24 April 2019

Reference: 190157.03FA

#### SUPPLEMENTARY TRAFFIC AND PARKING ADVICE FOR THE PROPOSED SAINTS PETER AND PAUL ASSYRIAN PRIMARY SCHOOL AT 17 - 19 KOSOVICH PLACE, CECIL PARK, 2178

CLIENT / Project:
Saint Peter & Assyrian Primary School

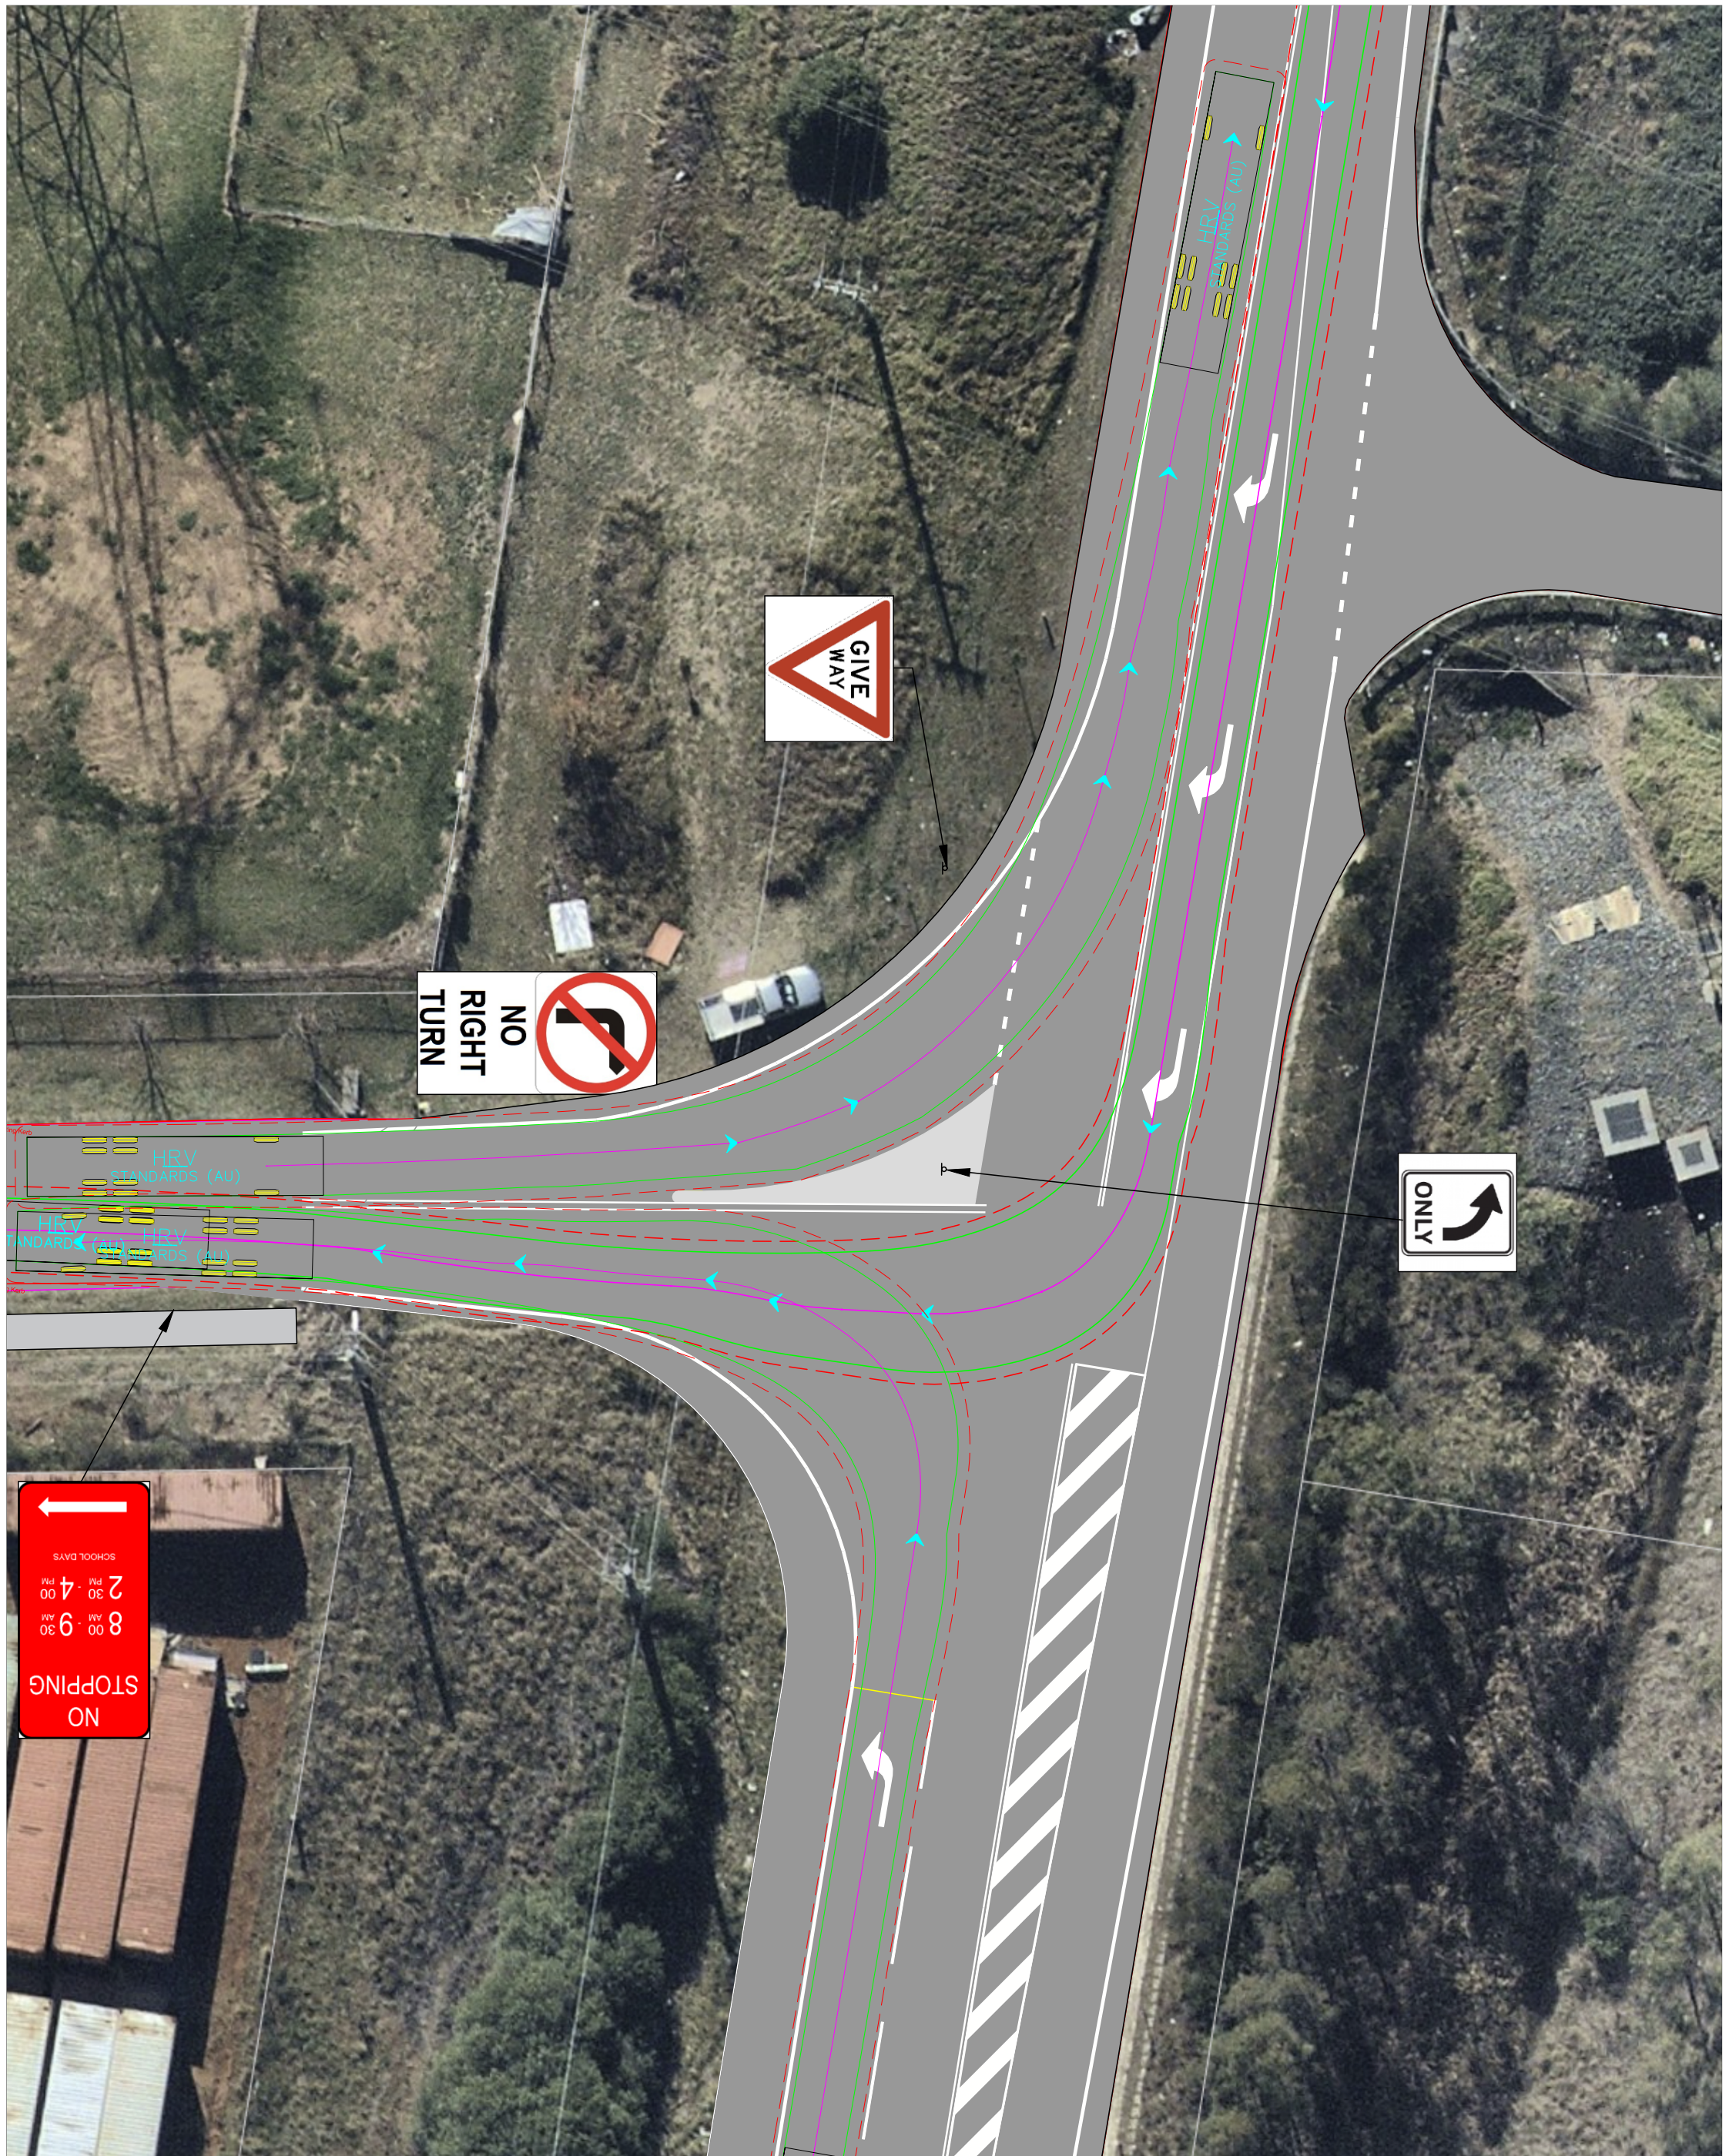
Considering Wallgrove Road is an 80km/hr speed zone road and right turning traffic has to negotiate with heavy volume of through traffic, RMS does not support proposed right turn bay (CHR) treatment on Wallgrove Road at Kosovich Place intersection. This would be a potential safety hazard for right turn traffic as motorists have to wait for a safe gap which could frustrate the drivers due to the high through traffic volume.

In addition, RMS does not support proposed banning of right turn from Kosovich Place into Wallgrove Road as this would increase unnecessary pressure at the roundabout of Wallgrove Road and Villiers Road.

RMS suggest a roundabout at the intersection of Kosovich Place and Wallgrove Road. It would improve the safety for turning traffic and also would reduce the approach speed at the subject intersection.

As indicated in **Table 1**, the SIDRA analysis indicates that right turning movements into Kosovich Place will experience low delays and limited queues will form. The proposed CHR treatment includes a queue storage length of 26.6m, which is more than sufficient to cater for the 6.3m of queues expected in the AM peak hour.

Considering the SIDRA results, it is unclear on what basis the RMS speculates that a safety hazard could be caused by right turning motorists waiting for a safe gap in traffic. SIDRA Intersection is a widely used and accepted intersection model in NSW and internationally and is relied upon regularly for the analysis of intersections.

On the basis of the above and the outcomes of the SIDRA Intersection modelling, a roundabout option is not needed and has not been investigated further.
